**KIRKLEES METROPOLITAN COUNCIL
INVESTMENT & REGENERATION SERVICE**

Reference No:	2023/62/93279/E
Site Address:	1, Judy Haigh Lane, Thornhill Edge, Dewsbury, WF12 0QB
Description:	Erection of first floor side extension and alterations
Recommending Officer:	Edward Cheseldine

HOUSEHOLDER DELEGATED REPORT

PROPOSED FIRST FLOOR EXTENSION TO
1 JUDY HAIGH LANE, THORNHILL, DEWSBURY FOR
MR B RAYNER
Drawing No 02

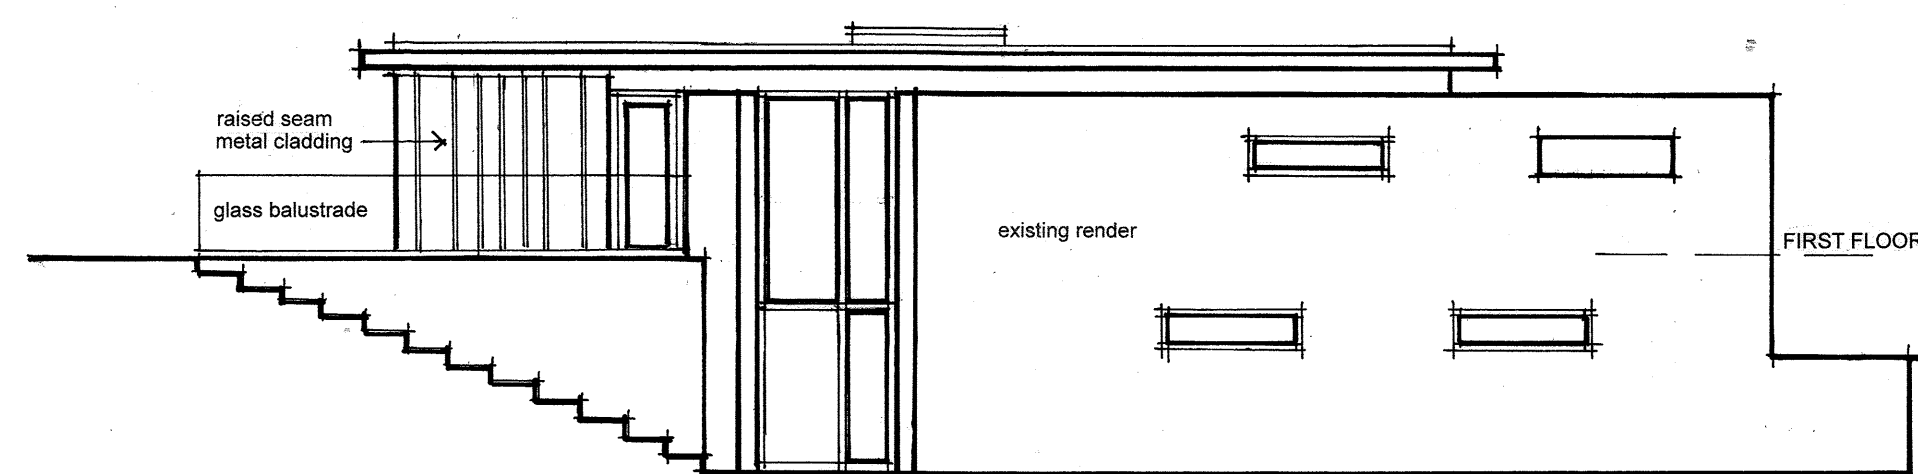
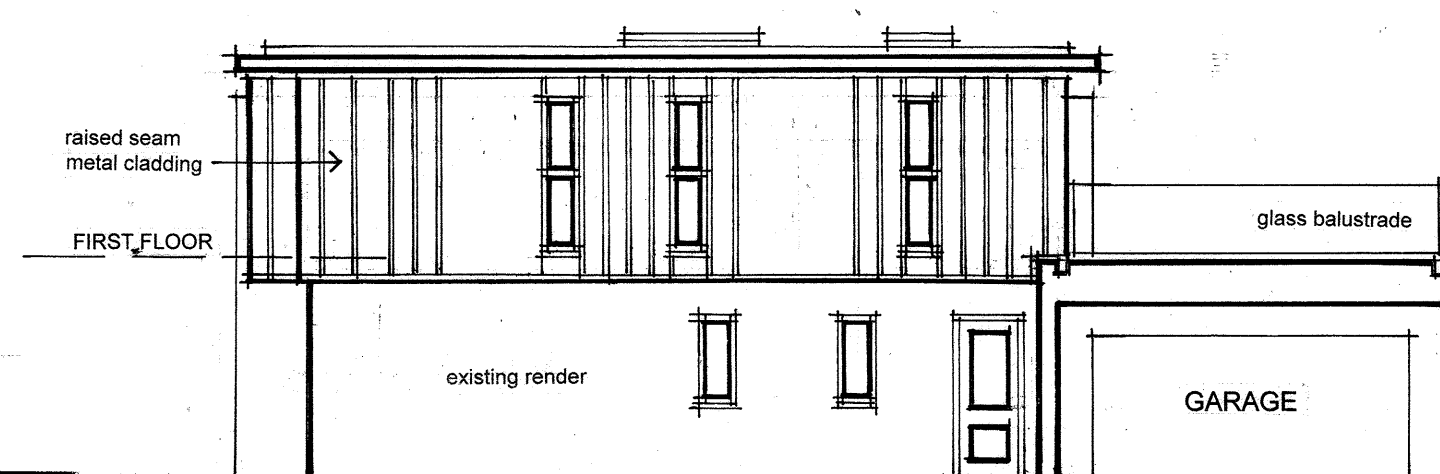
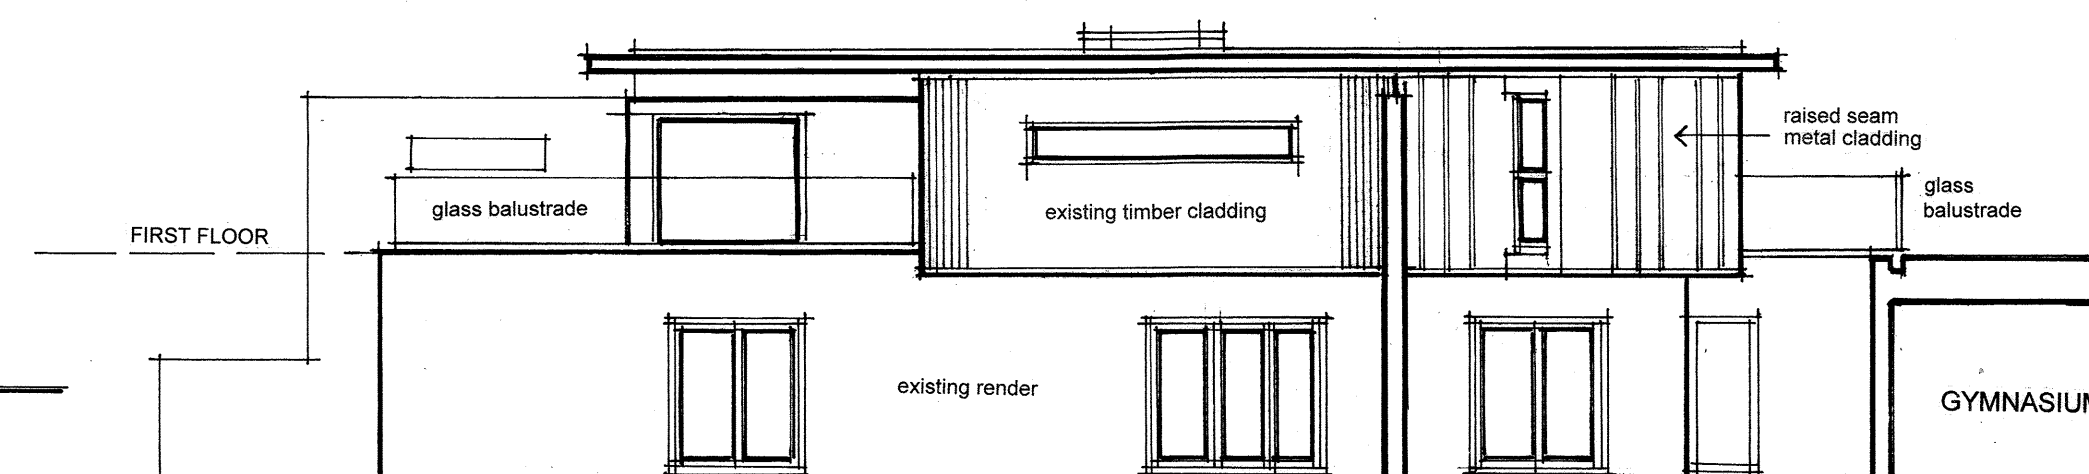
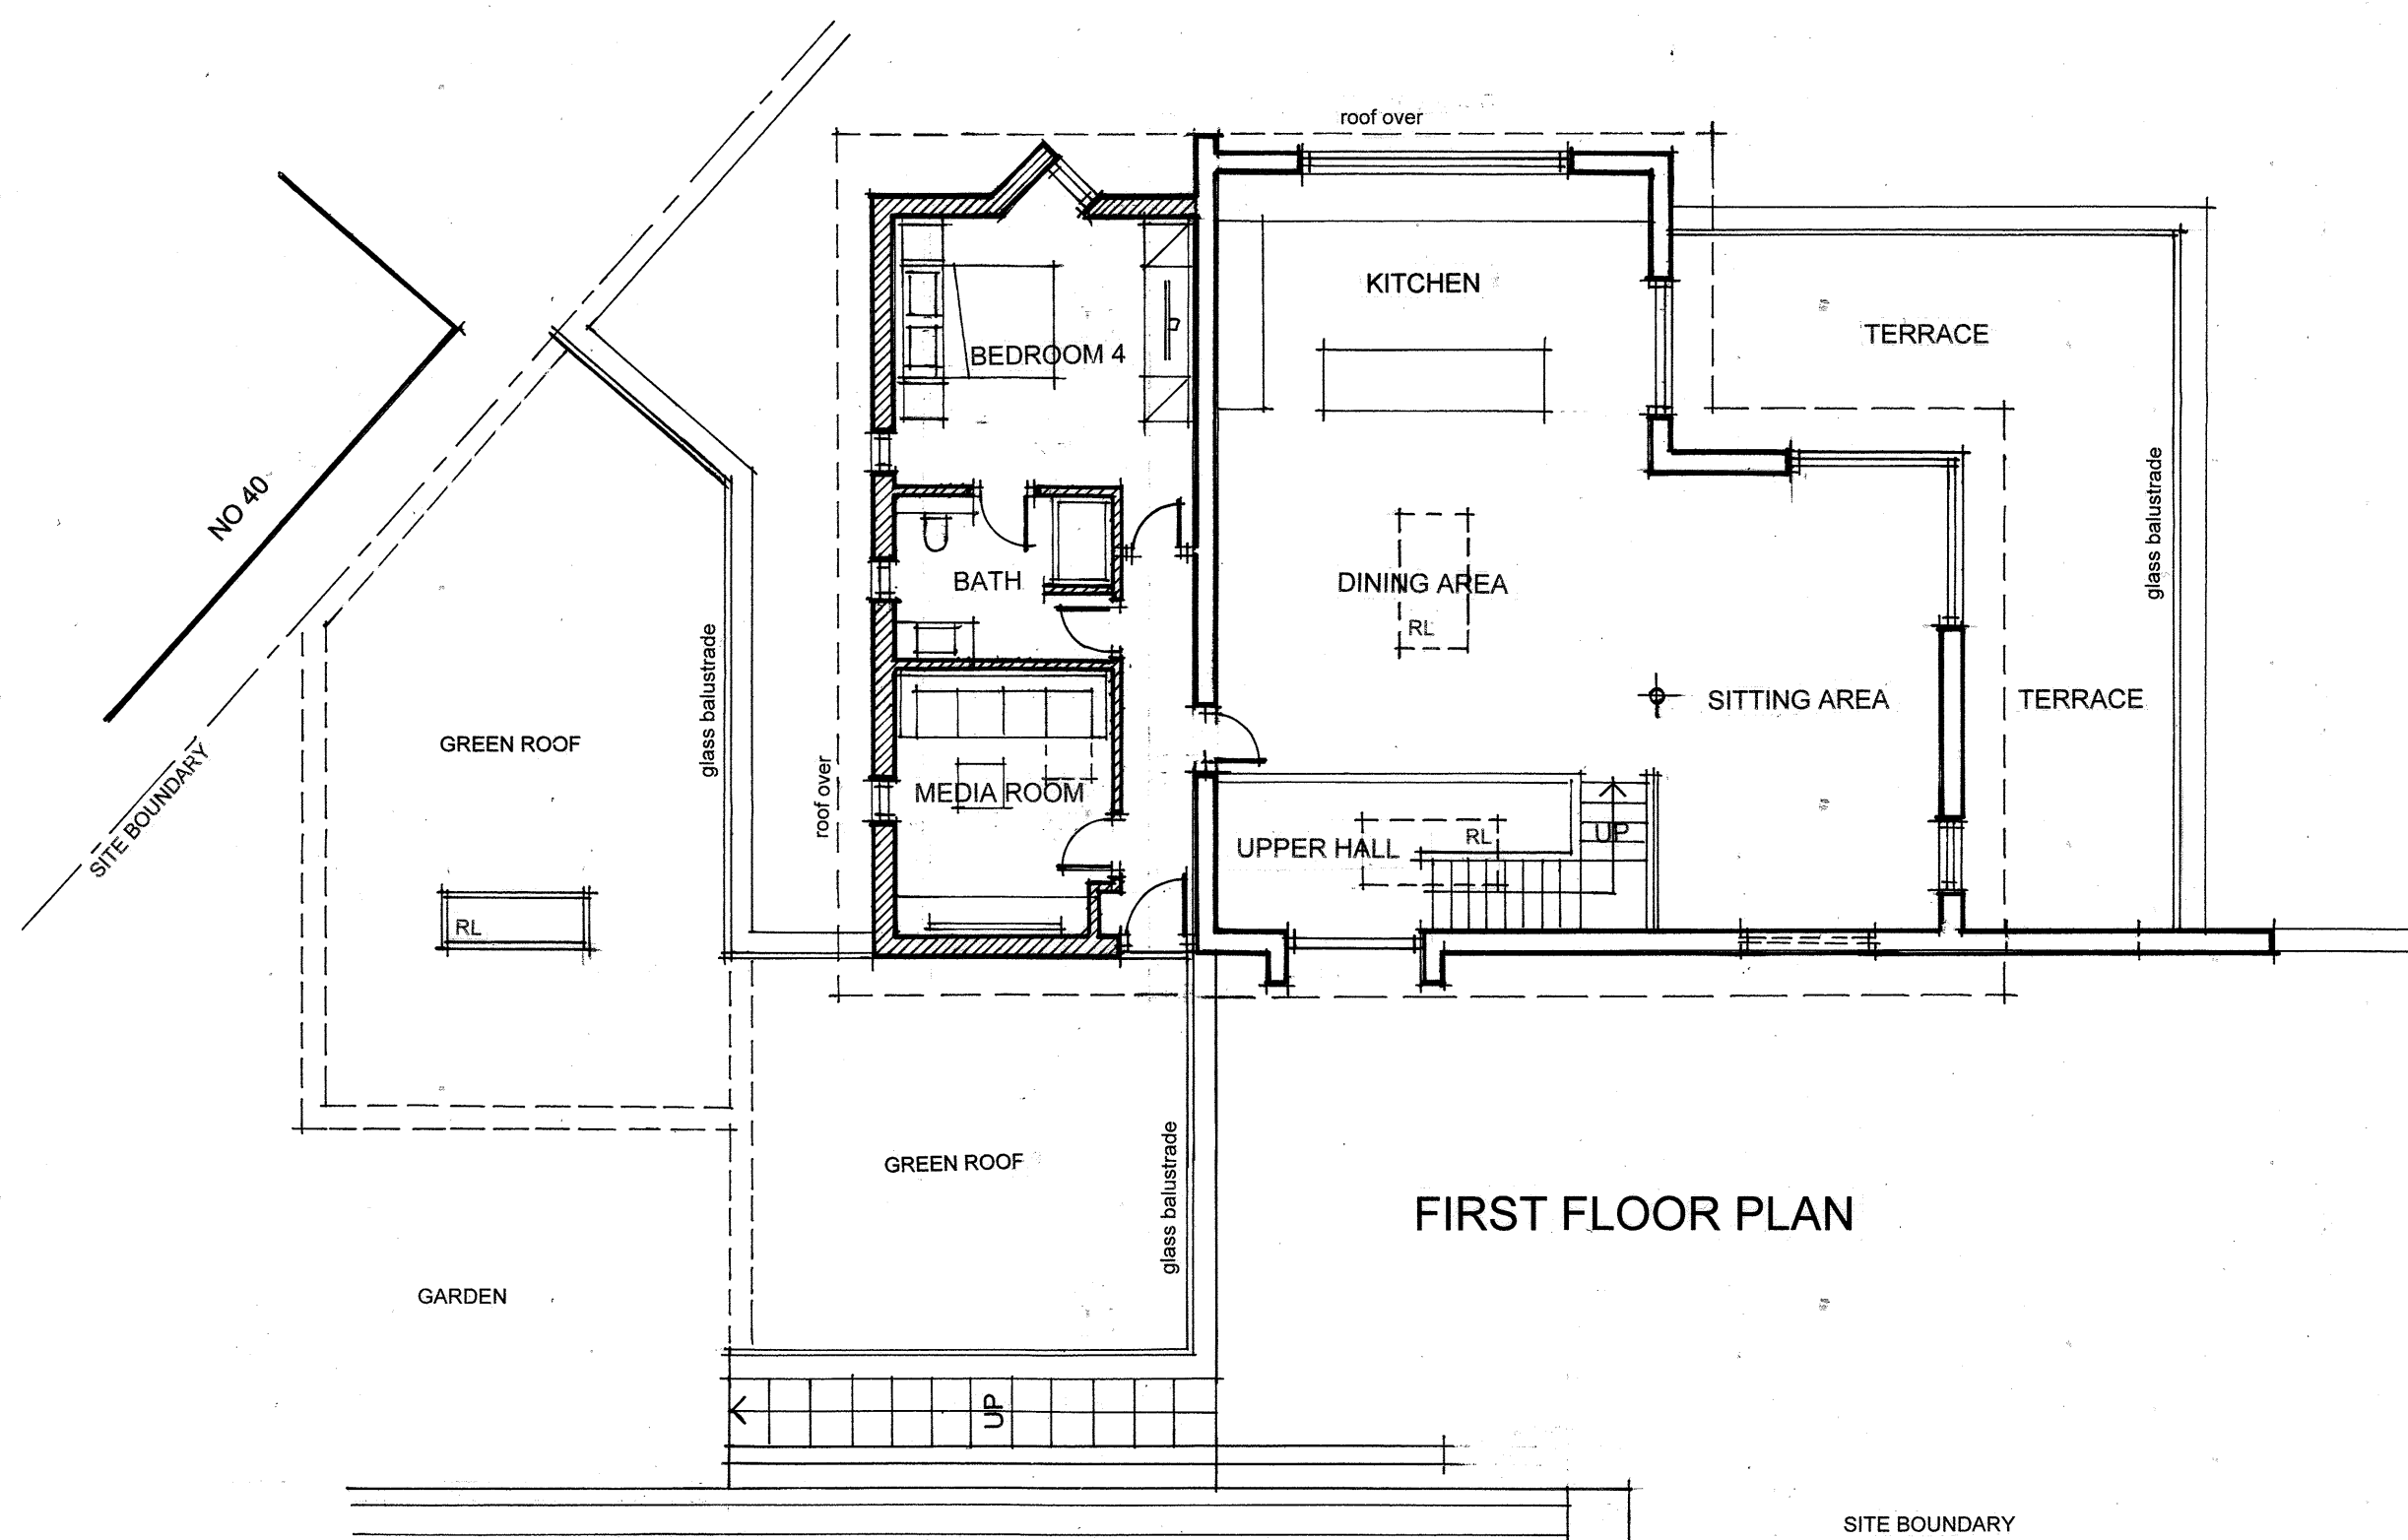
<u>Yes - COMPLY</u>	<u>No - JUSTIFY</u>
Not take up all or most of the space to the side of a house	Yes	
Maintain a 1 metre gap to the side boundary to ensure the building is not too close to a neighbouring property	Yes	
Be set back at least 500mm from the front wall of the house	No	The dwelling has a modern architectural design drawing on the use of rectangular shapes and right angles, denoting a 'Bauhaus' influence. In this instance, a 'set back' approach would harm the original character of the dwelling by deviating from the angular form of the original house .

Impact on light and outlook of neighbours (to sides, rear and front)	• KDP 4, 5, 6 of the SPD • Policy LP24 Design (b) • Chapter 12 of the NPPF	As there is a subsection to the ground floor section of the building, the height of the two-storey element will be ~2.80m from ground level at a distance of ~2.20m to the shared boundary.	✓

Due to the height above ground level of the two-storey element and distance to the boundary, there will not be a loss of light. The distance from the side windows will mitigate a loss of outlook. A window is proposed to light a W/C area. In order to protect from privacy, it will be conditioned that this window is obscurely glazed.	
--	--	--	--

3. The extension shall not be occupied until the W/C window in the side elevation of the extension hereby approved has been obscurely glazed (to a minimum Grade 4). Notwithstanding the provisions of the Town and Country Planning (General Permitted Development) Order 2015 as amended (or any Order revoking or re-enacting that Order) the obscure glazing (to a Grade 4) shall thereafter be retained.
